**re: Grading and Site Servicing Plans Review  
Proposed Church**  
3555 Borrisokane Road, Ottawa, Ontario

**date:** February 22, 2024

**file:** PG6842-MEMO.02 Revision 1

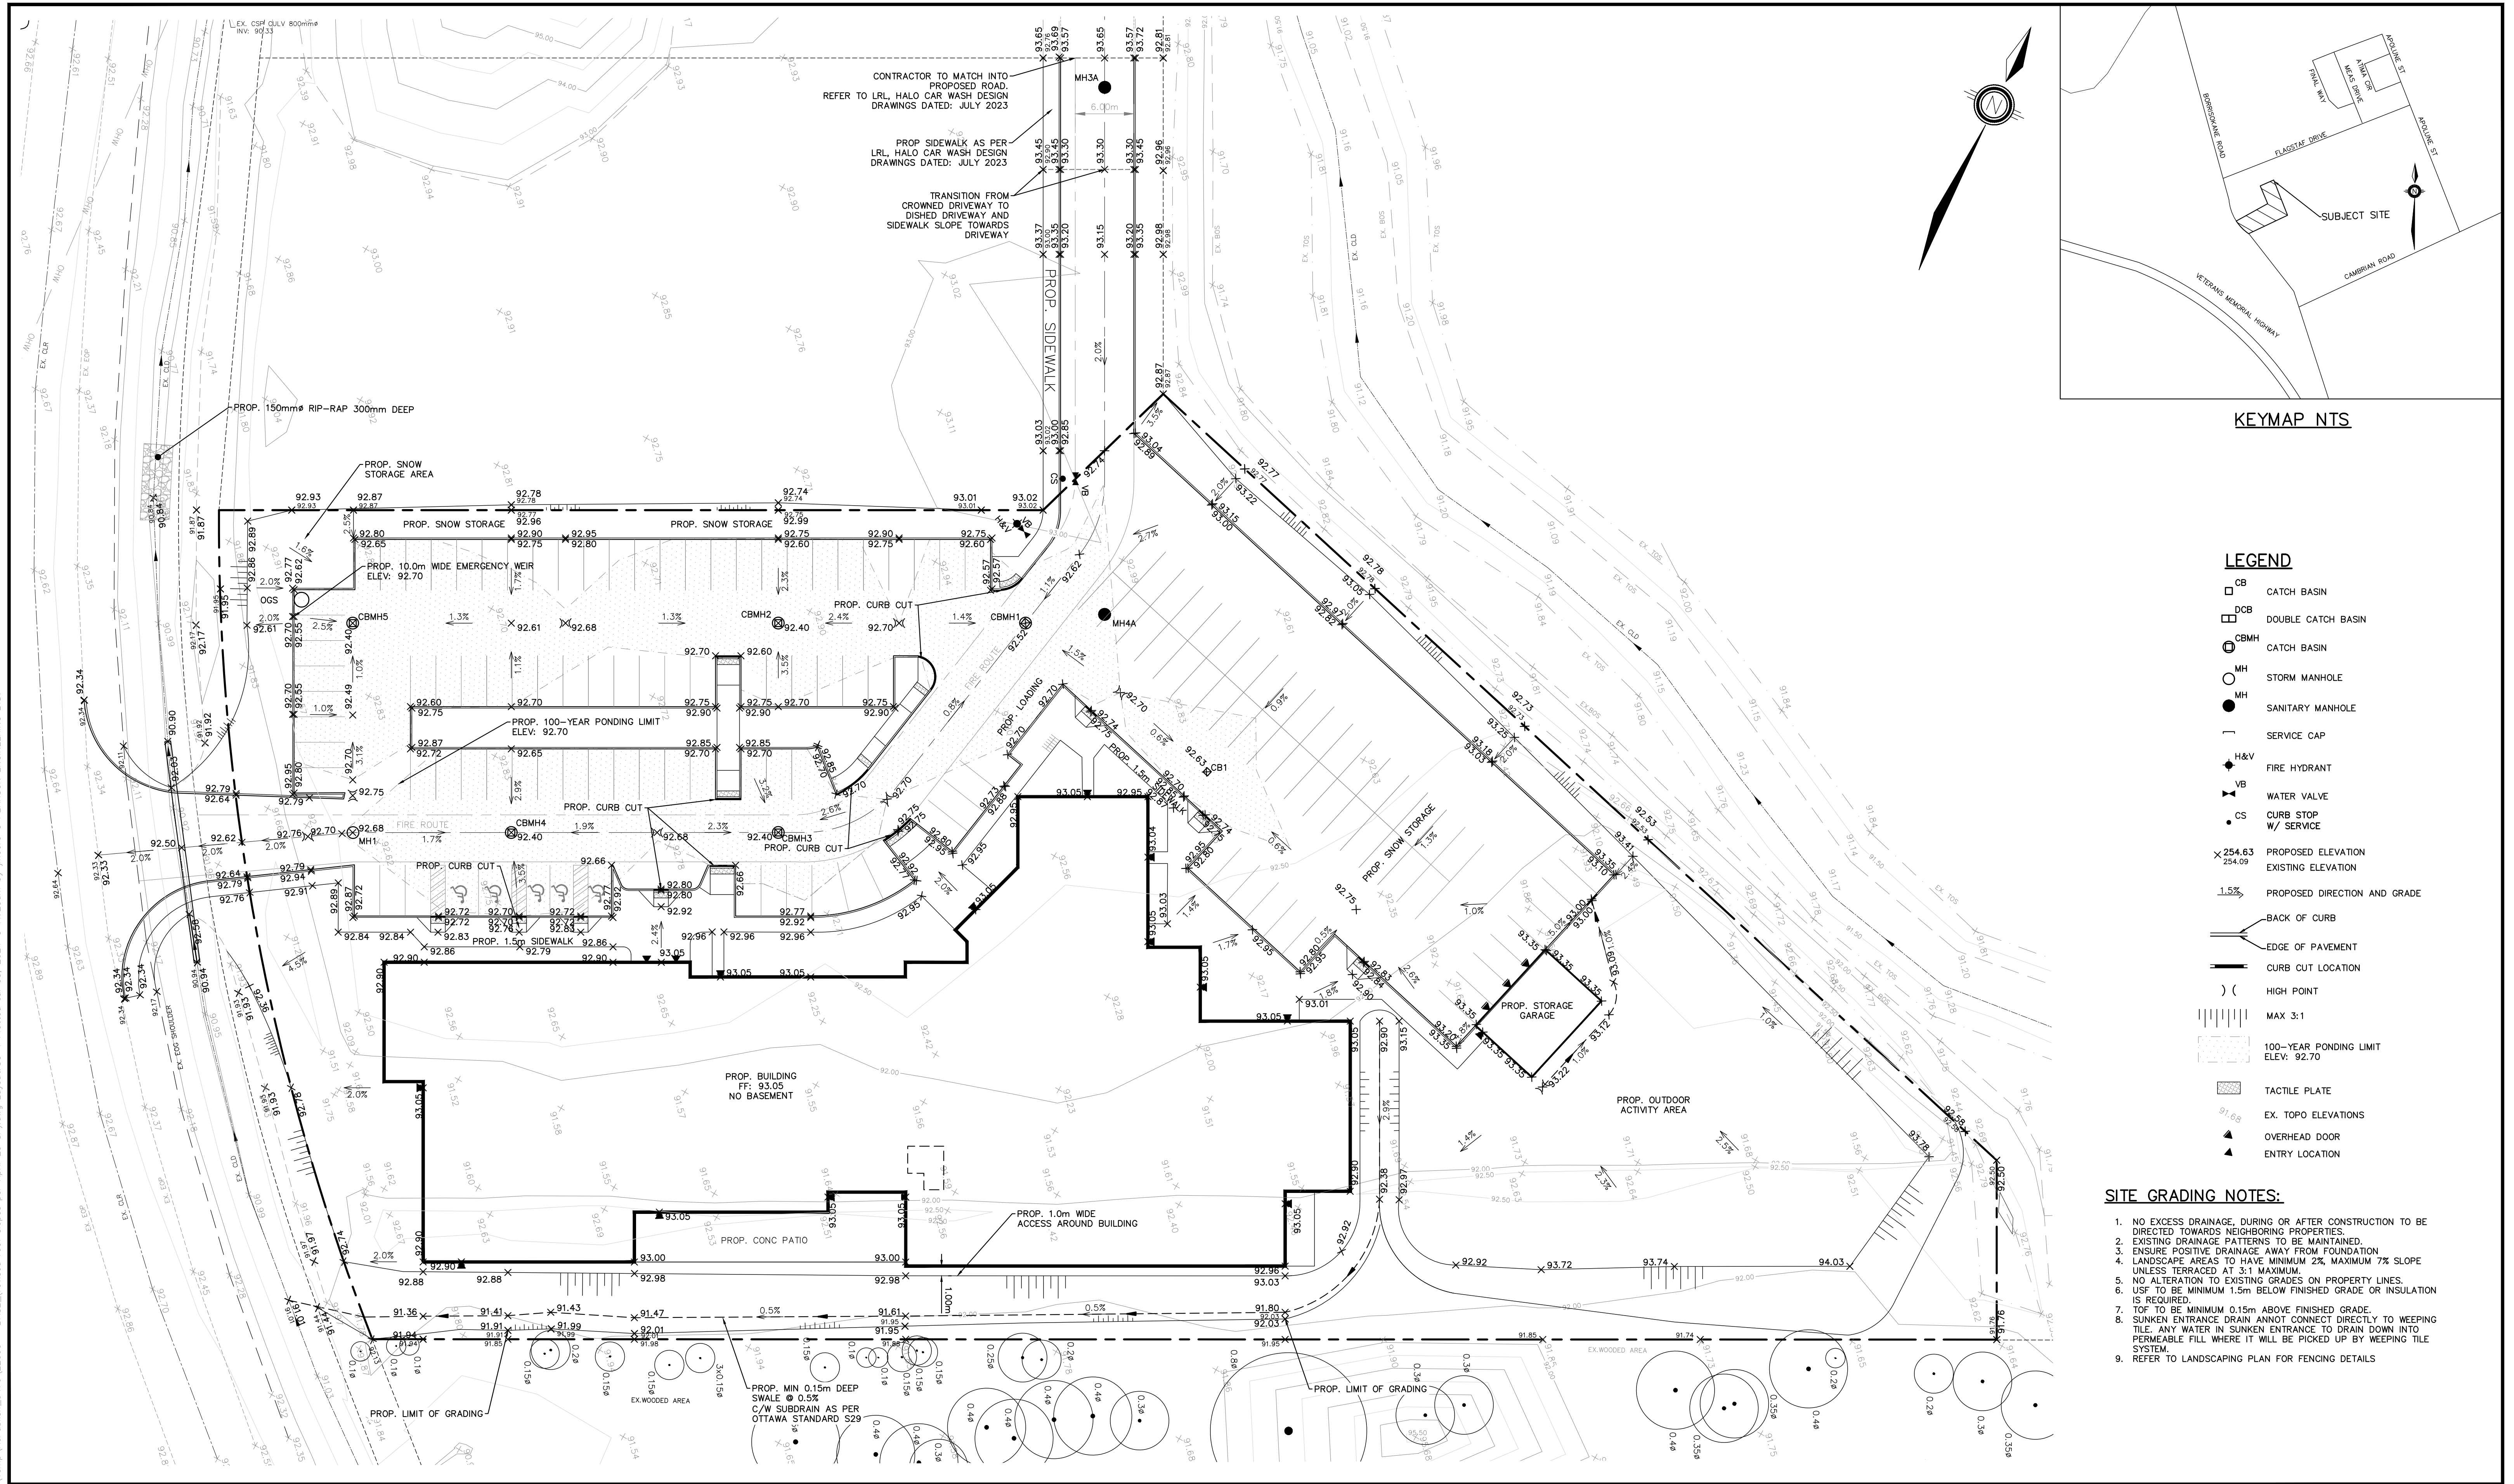
Paterson has reviewed the subsurface conditions within the footprint(s) of the proposed buildings. Based on our review, **a permissible grade raise of 1.0 m** is recommended for finished grading within 6 m of the proposed building footprint. **A permissible grade raise of 1.5 m** can be used only for the grading of parking areas, access roads, and landscaping areas.

Based on our review of the above-noted drawing, the proposed grading was found to be within the permissible grade raise of 1.5 m for the proposed parking areas, access roads, and landscaping areas. However, based on the finished floor elevations and proposed grade raise around the building, lightweight fill (LWF) should be placed below the middle portion of the proposed building footprint with a minimum thickness of 600 mm as shown in Figure 2 attached to the current memorandum. In addition, The LWF shall extend 6m beyond the face of the building as presented area in Figure 2.

Reference should be made to Figure 1 - EPS Block Installation Recommendations and to Figure 3 - Marked-Up Grading Plan Indicating the Extent of LWF. It shall be noted that the LWF shall not extend vertically below the USF. The LWF should consist of EPS (expanded polystyrene) geofam blocks, which allow for raising the grade without adding a significant load to the underlying soils. For this application, EPS type 15 should be used.

SITE SERVICING PLAN

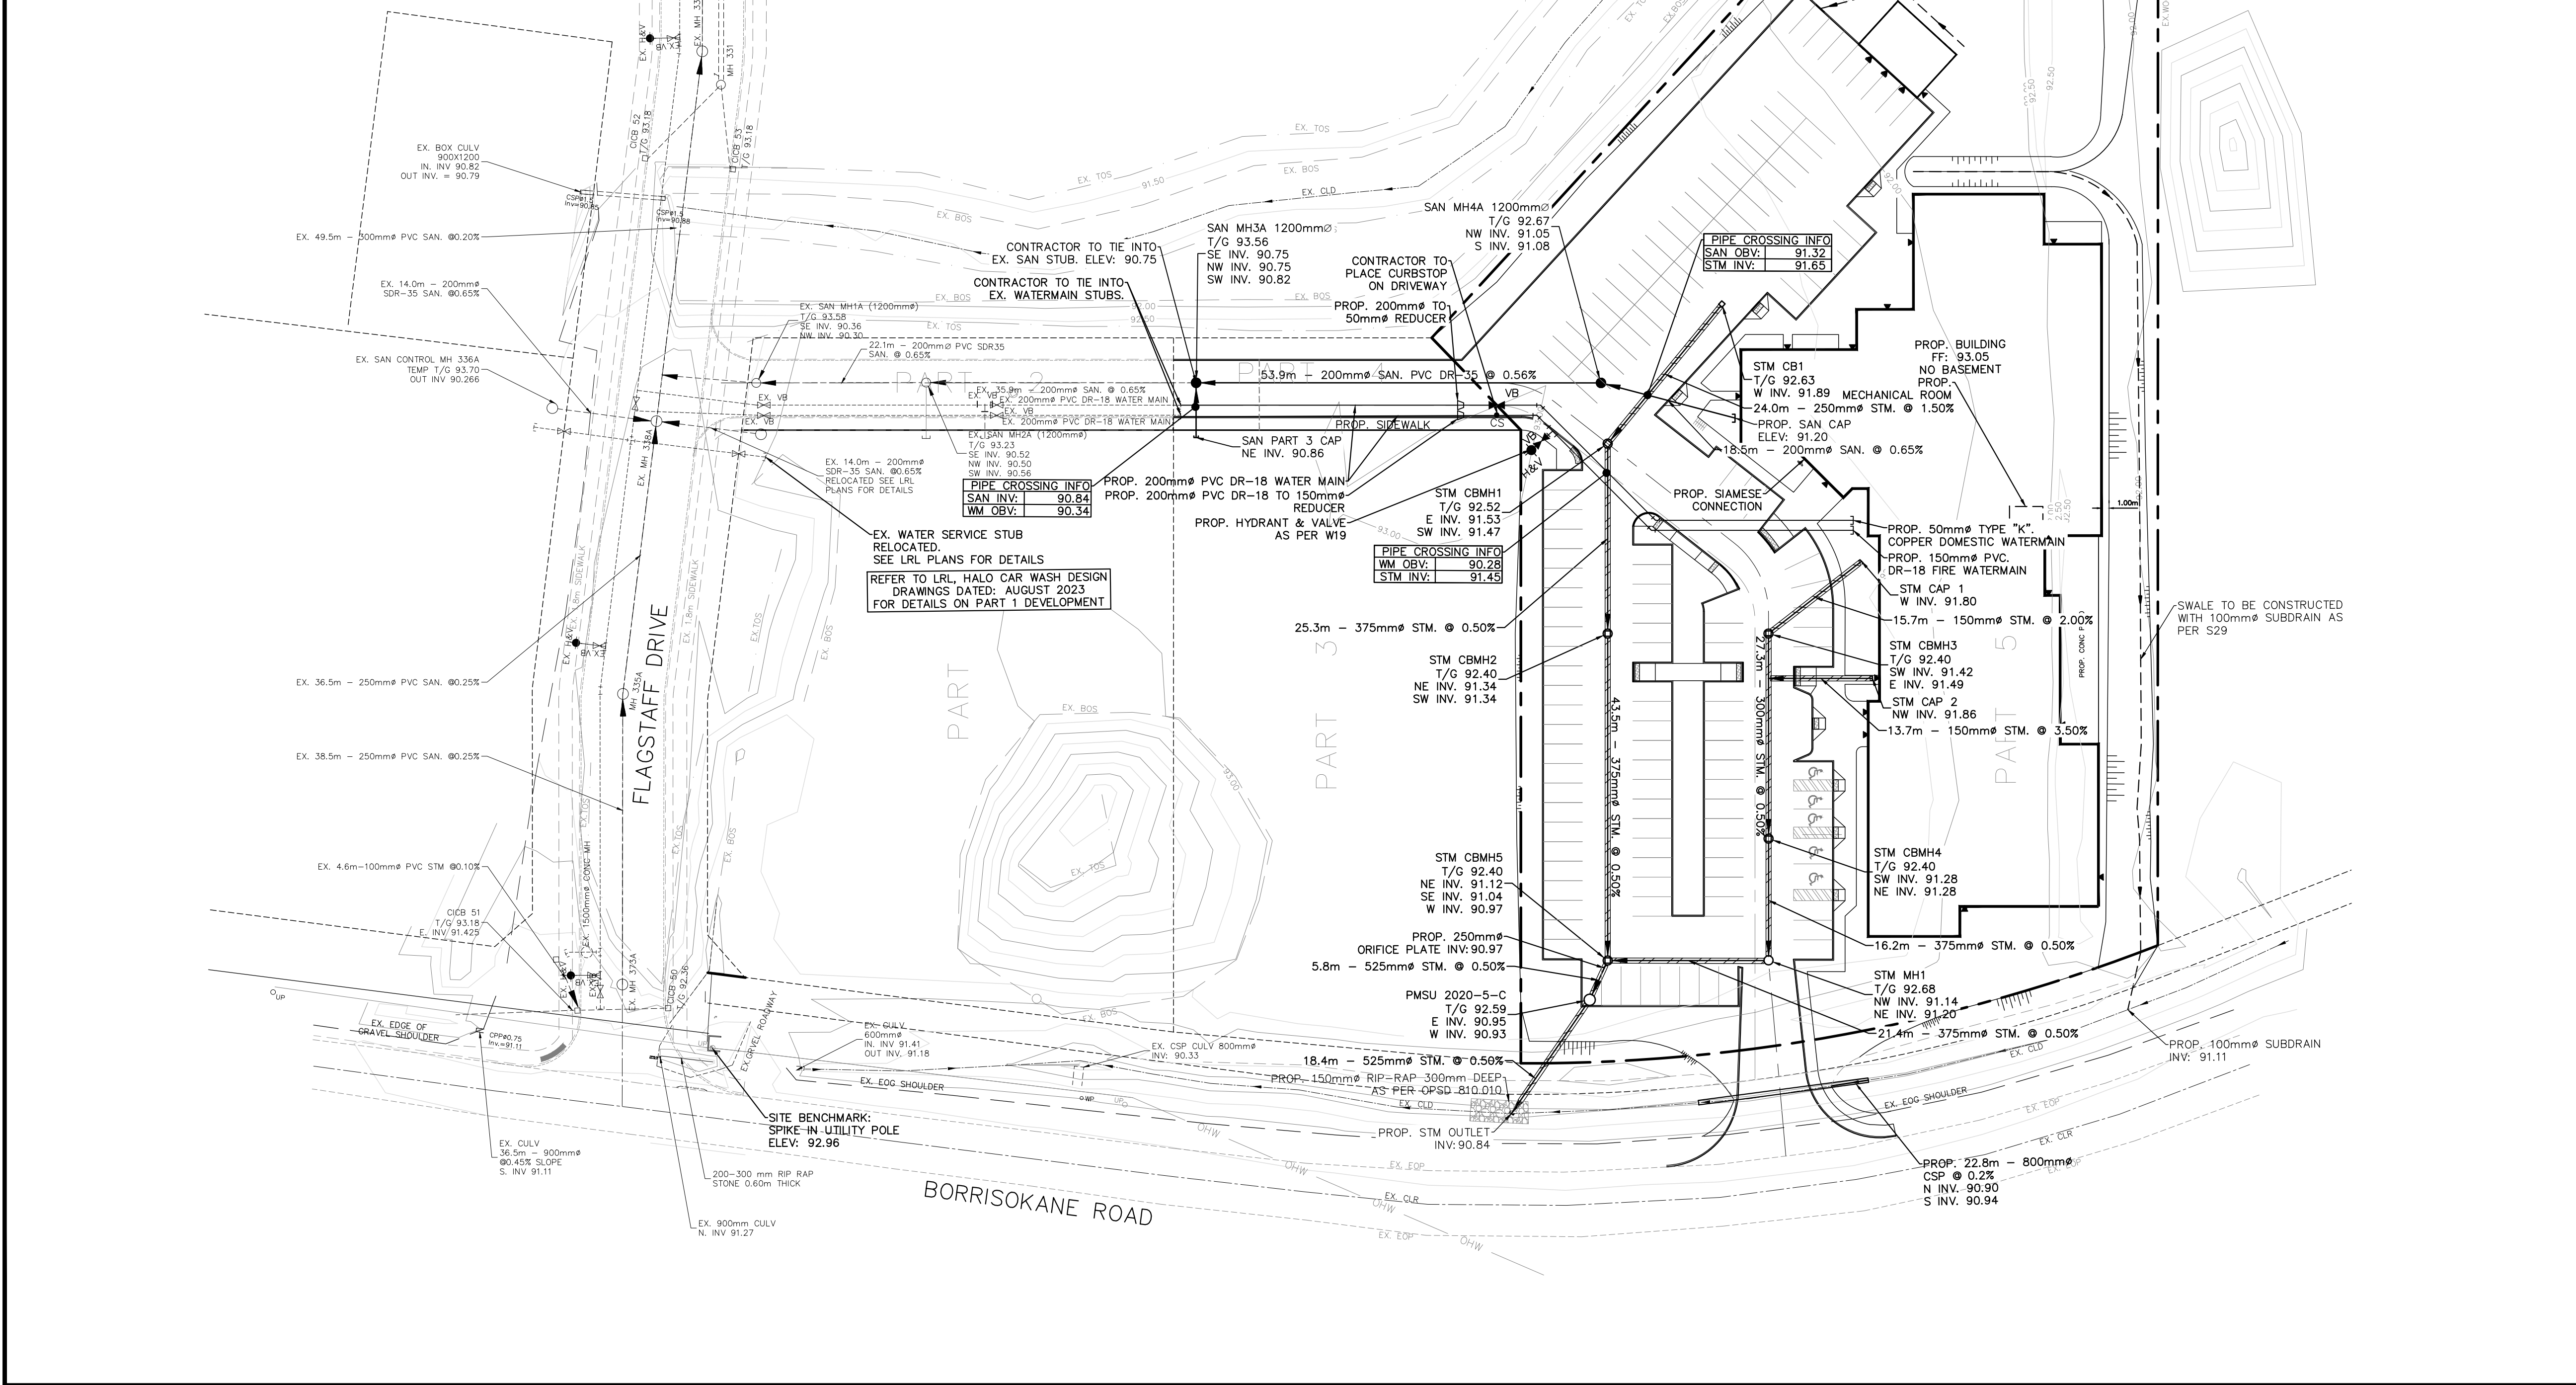
Based on our review of the above-noted site service plans, it should be noted that all services will be constructed outside the lateral zones of the proposed footings of the building and are considered to be acceptable from a geotechnical perspective.

Further, it should be noted that all watermain pipes have been provided with sufficient soil cover at the subject site for the frost protection. However, insufficient frost protection has been provided for the majority of the proposed storm and sanitary sewer pipes throughout the subject site. The proposed storm and sanitary sewer pipes are located within the frost zone, approximately 2.1 m below the finished grade. In the following section, frost protection of the site servicing is recommended where insufficient frost cover has been provided. Reference should be made to Figure 4 - Marked-Up Site Servicing Plan indicating where insufficient frost cover has been provided, attached to the current memorandum.

Any portion of the services installed at a depth of 2.1 m below finished grade or deeper is considered to have sufficient soil cover for frost protection. Where insufficient soil cover is present above the invert of storm and sanitary sewer pipes, the following frost protection criteria should be followed:

All rigid insulation should consist of either Dow Chemical High-Load 40 (HI-40), Styro Rail SR.P400, or equivalent approved by Paterson. The placement of all insulation within the service trenches must be reviewed and approved by Paterson personnel at the time of construction. Reference should be made to Figure 2 - Typical Frost Insulation Detail, attached to this memorandum.
